Re: Bass Point Quarry Project (08_0143) – Exhibition of Environmental Assessment

DPI Fisheries has reviewed the Environmental Assessment (EA) by Insite P/L (dated June 2010) and Appendices provided by the applicant and makes the following comments and recommendations.

TITLE: BASS POINT QUARRY - SITE PLAN AND SURFACE WATER MANAGEMENT	SHEET 2
PROJECT MANAGER: ANDREW NORRIS	DRAWING NUMBER: P0902486JD05V01
OF 3 SHEETS

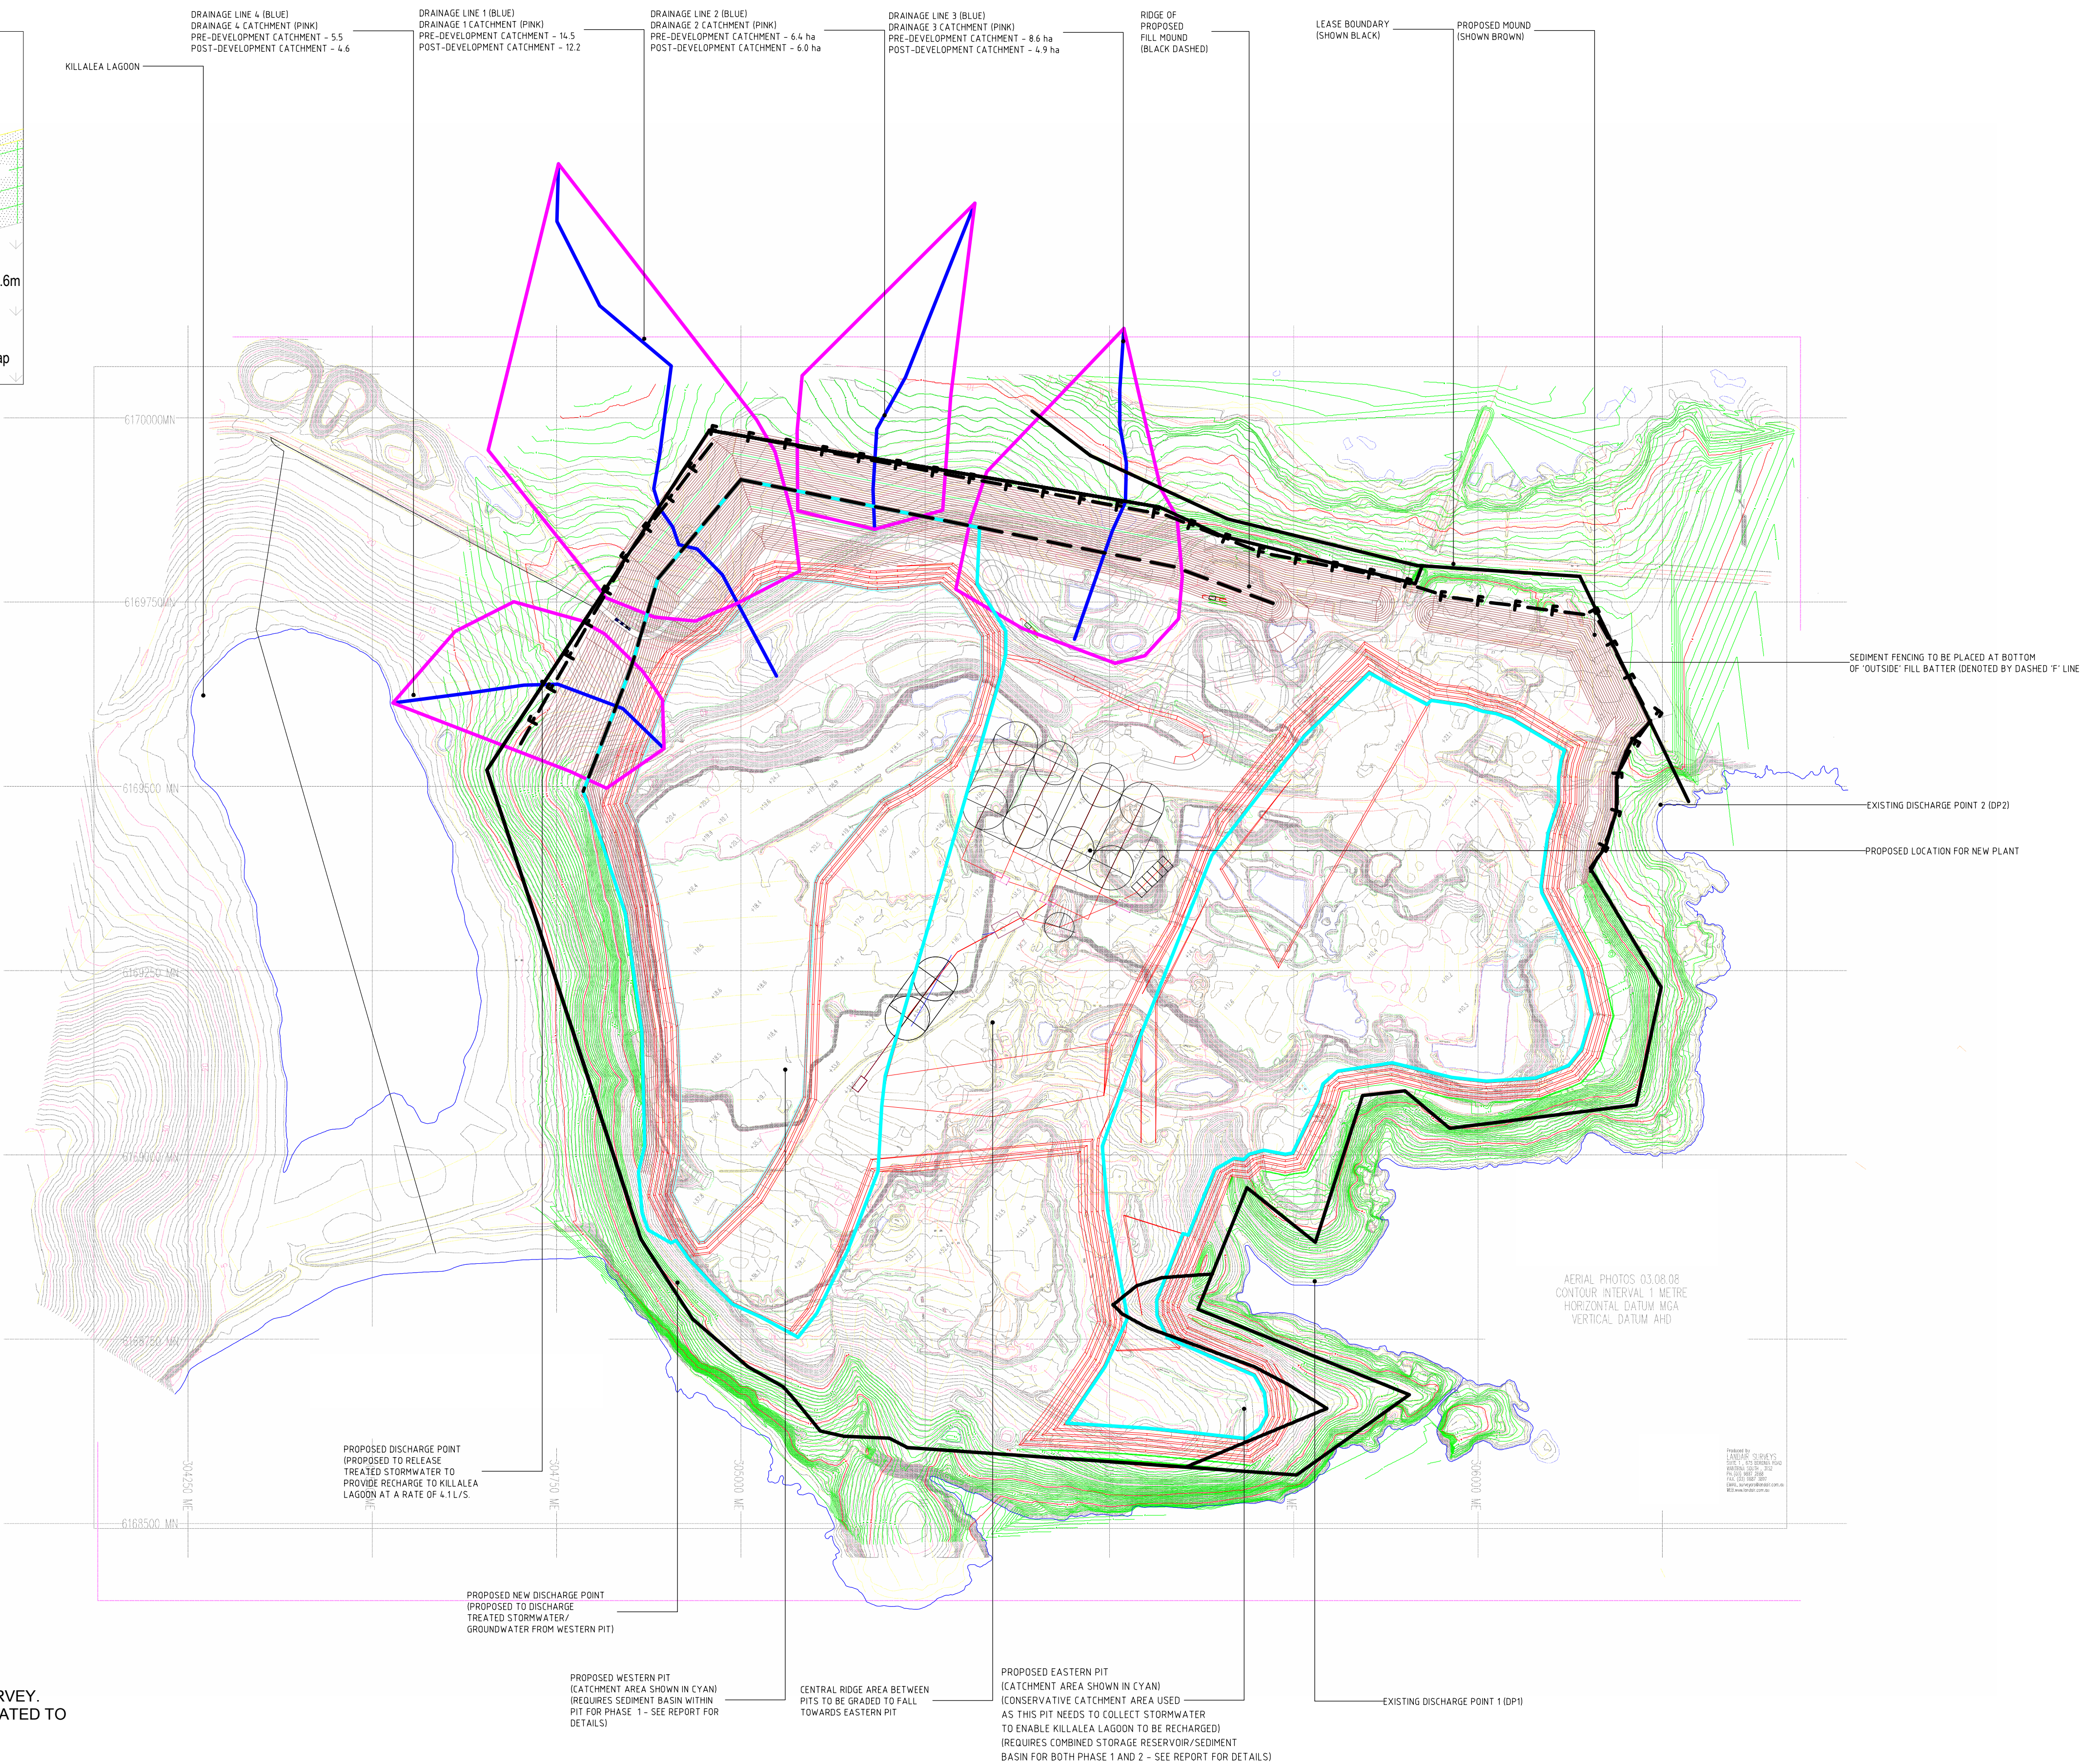
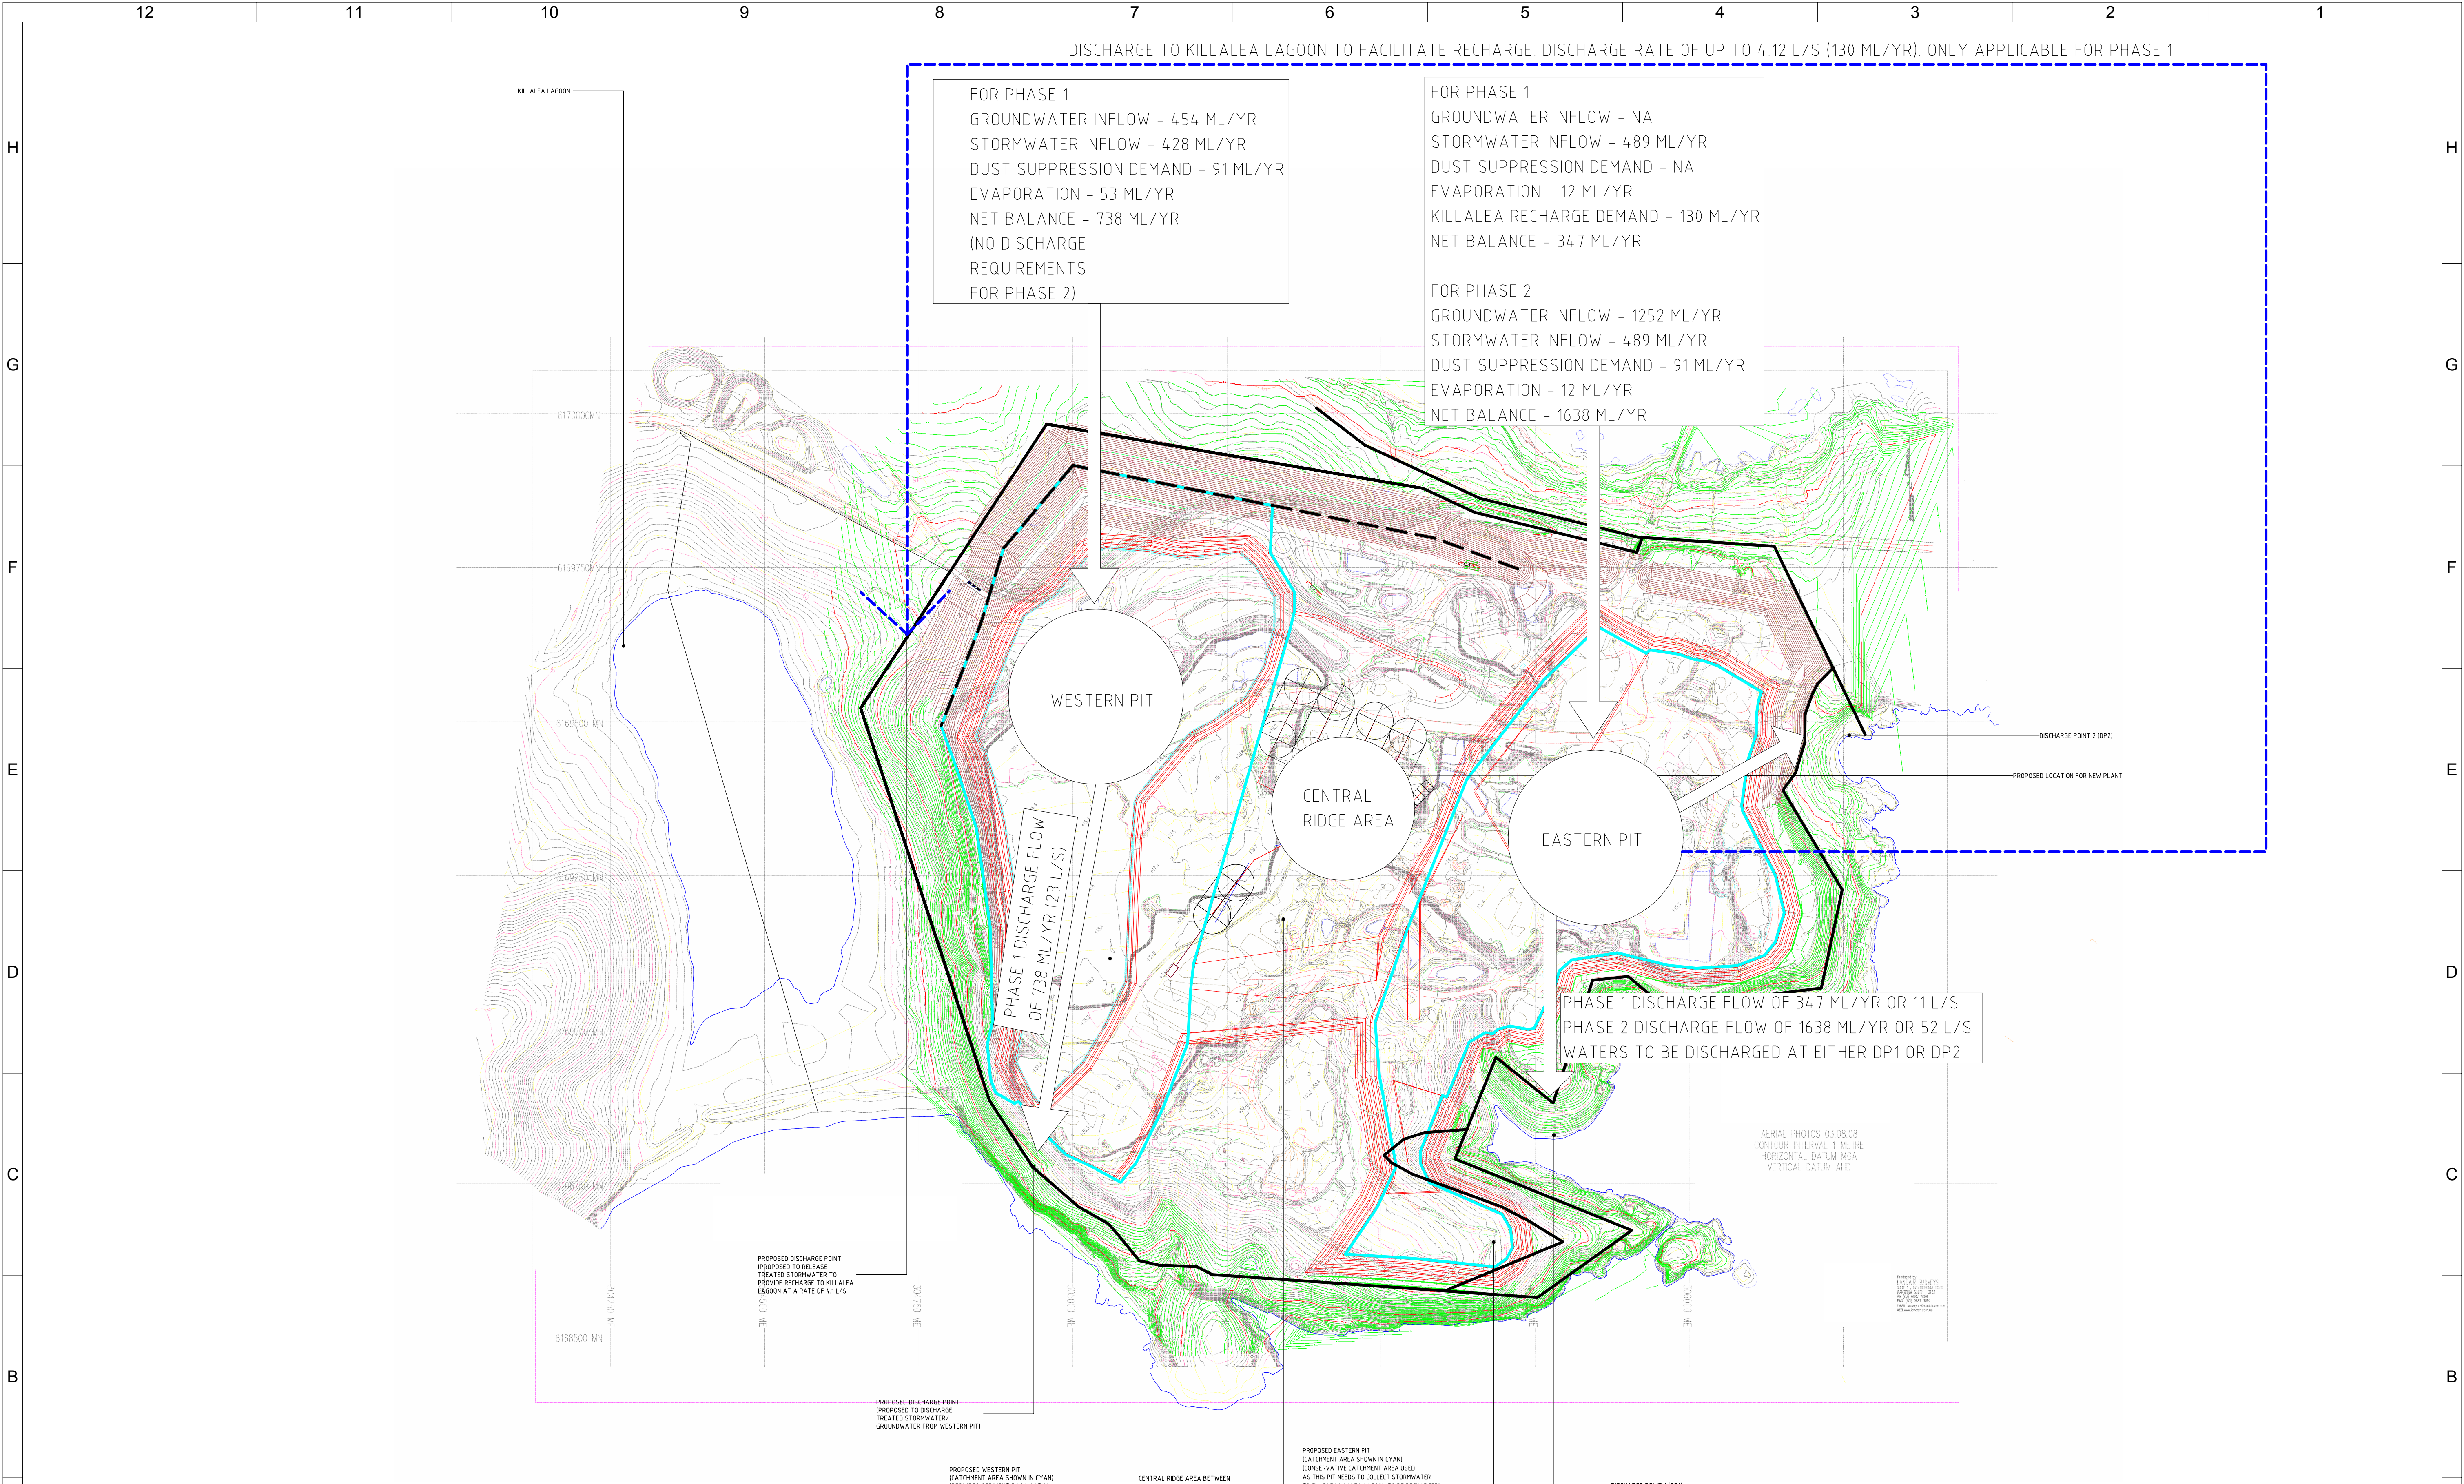
DPI Fisheries concurs with the commitment (section 8.10.8 of EA and Attachment 16 p.13) to ensure that all site discharges are treated to meet the following discharge criteria prior to release:

- TSS <50 mg/L
- Oil and Grease < 5 mg/L and none visible on ponds prior to discharge
- pH of 6.5 – 8.5

DPI recommends that this commitment is made mandatory in any approval of the project.

Given the past history of non-compliance with monitoring of the ocean discharge points at this site under Environmental Protection Licence (EPL) #2193 (see Attachment 16 – Sediment and Erosion Control Plan p.12), DPI Fisheries recommends that any approval of the proposal should include conditions that require regular audits to be conducted by the Office of Environment & Heritage (OEH) to ensure that all conditions of the EPL are complied with in future.
